31 Fore St - Final Review Comments

Re: Final Review Comments for 31 Fore St. – Proposed Four Unit Building

C-01

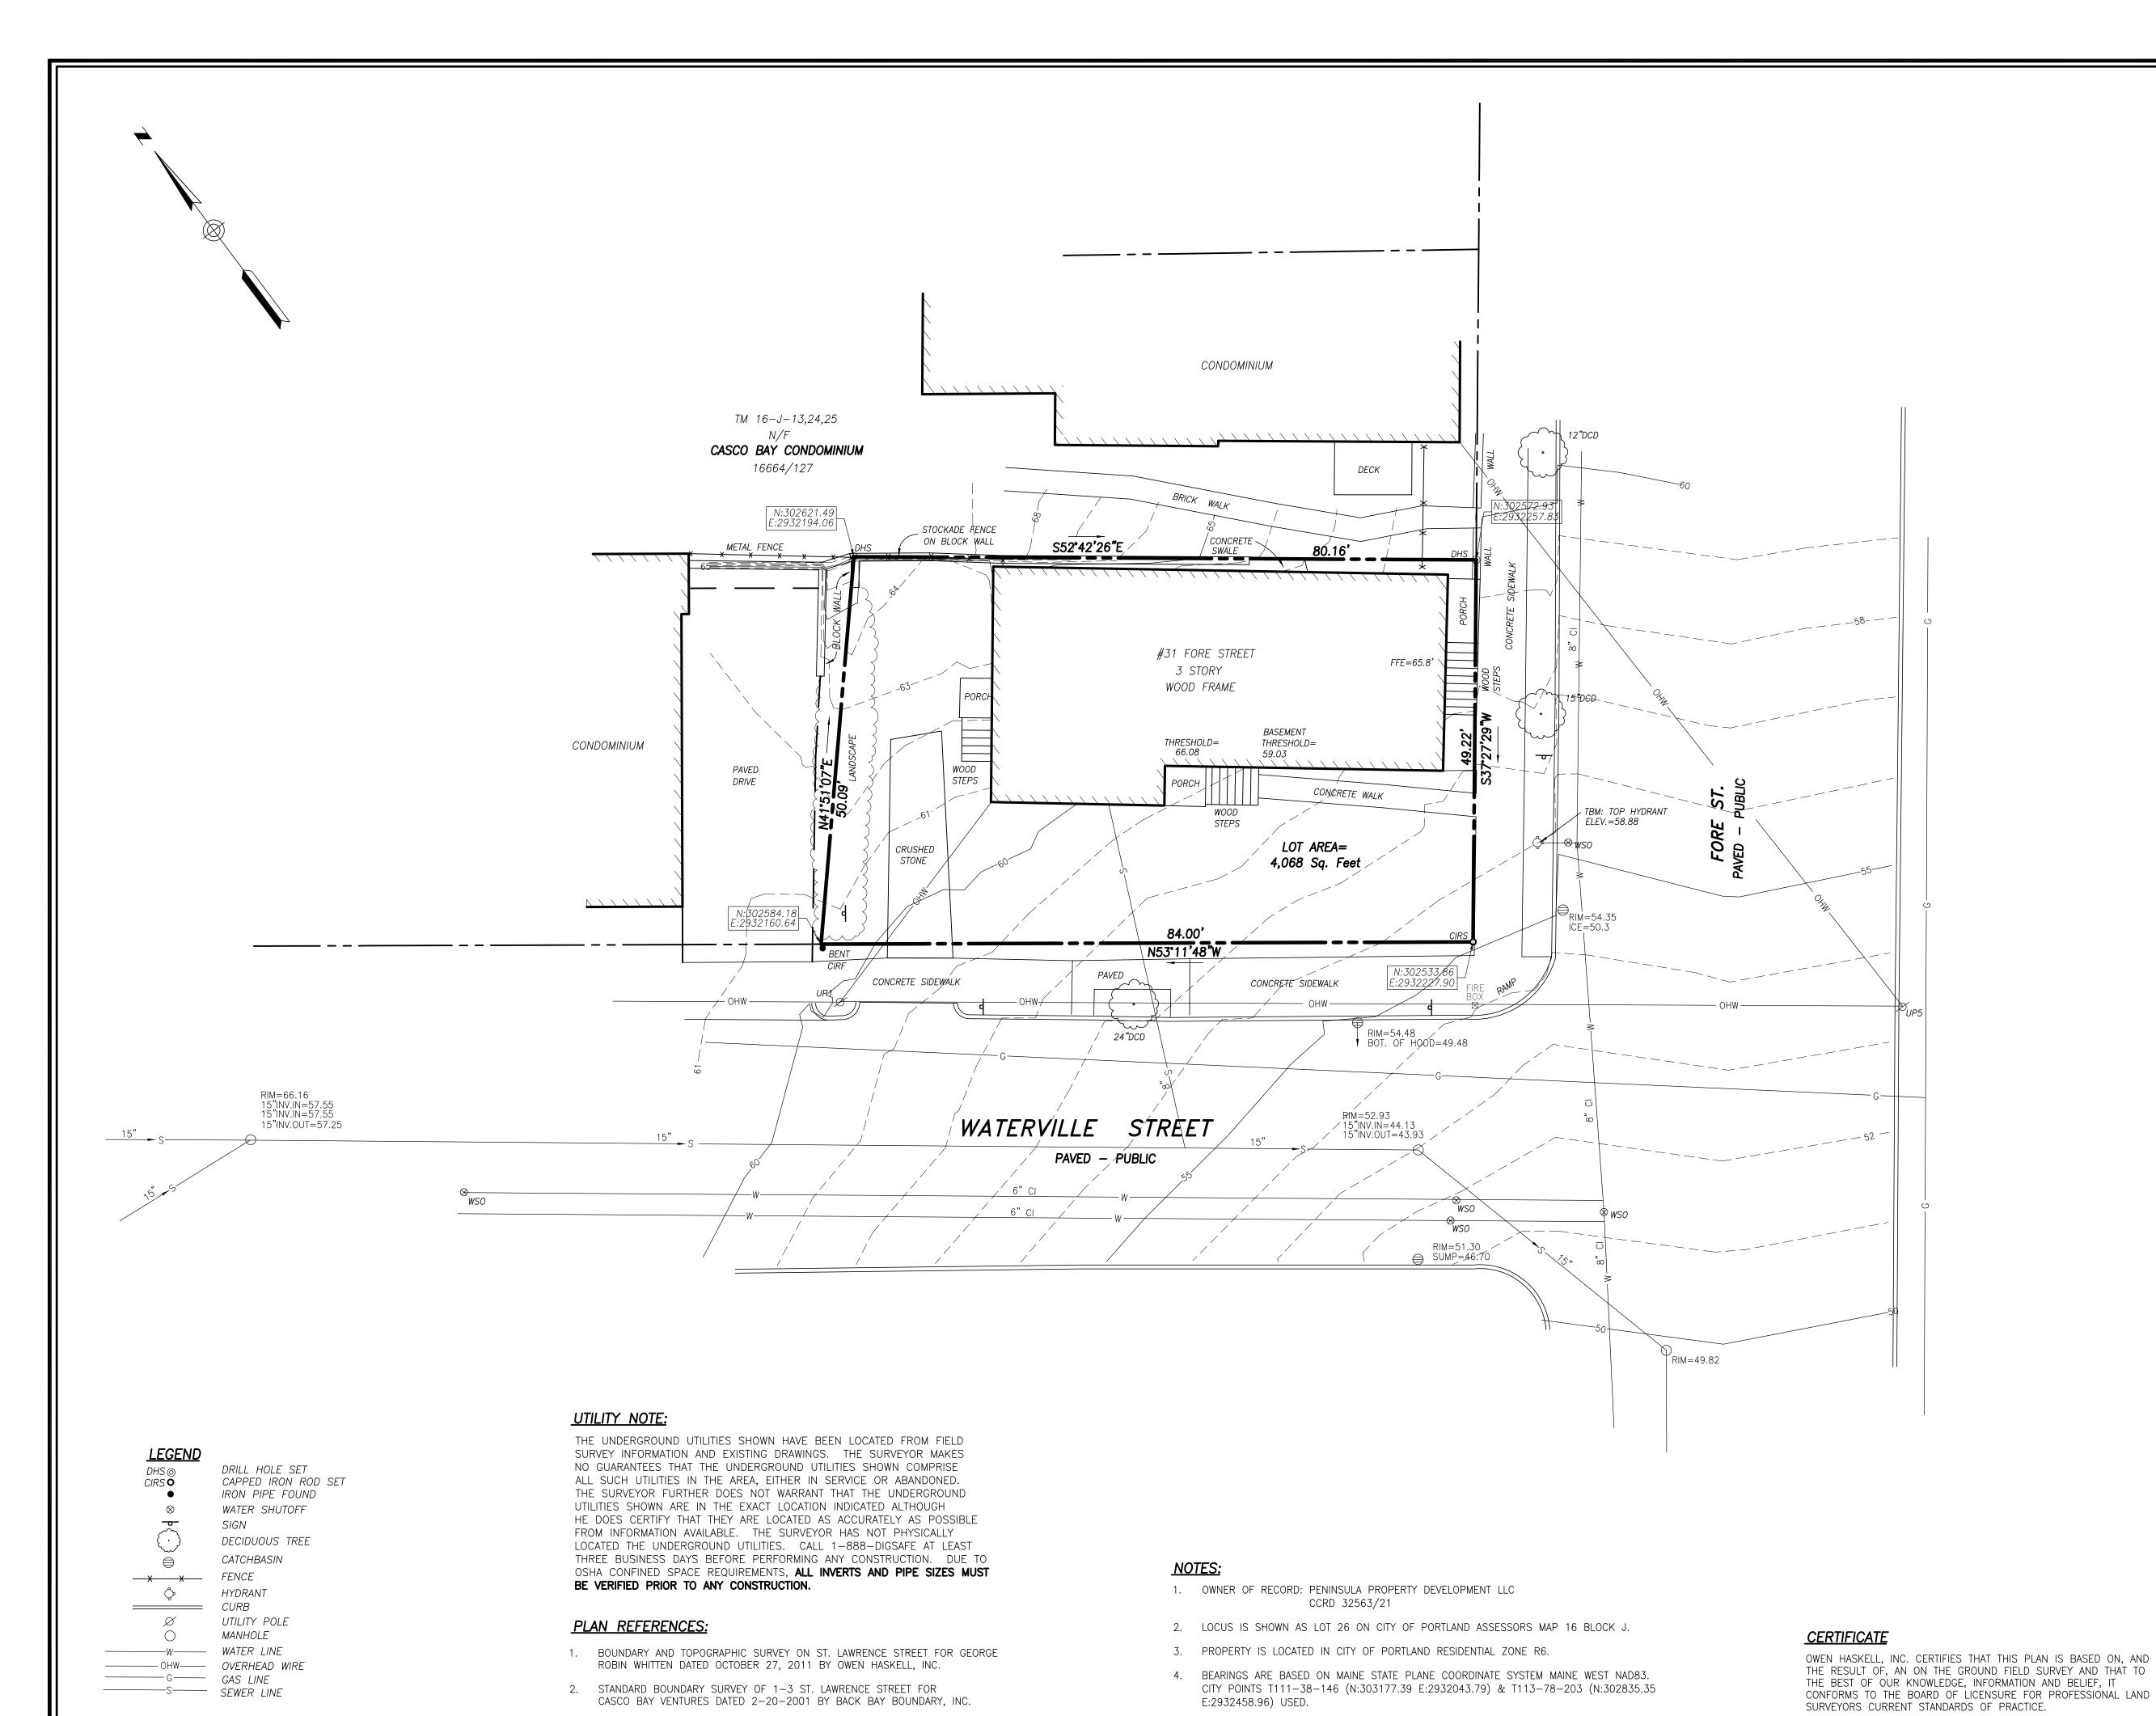
2. Show the monument to be set on the Site Plan in addition to the Subdivision Plat.

Done
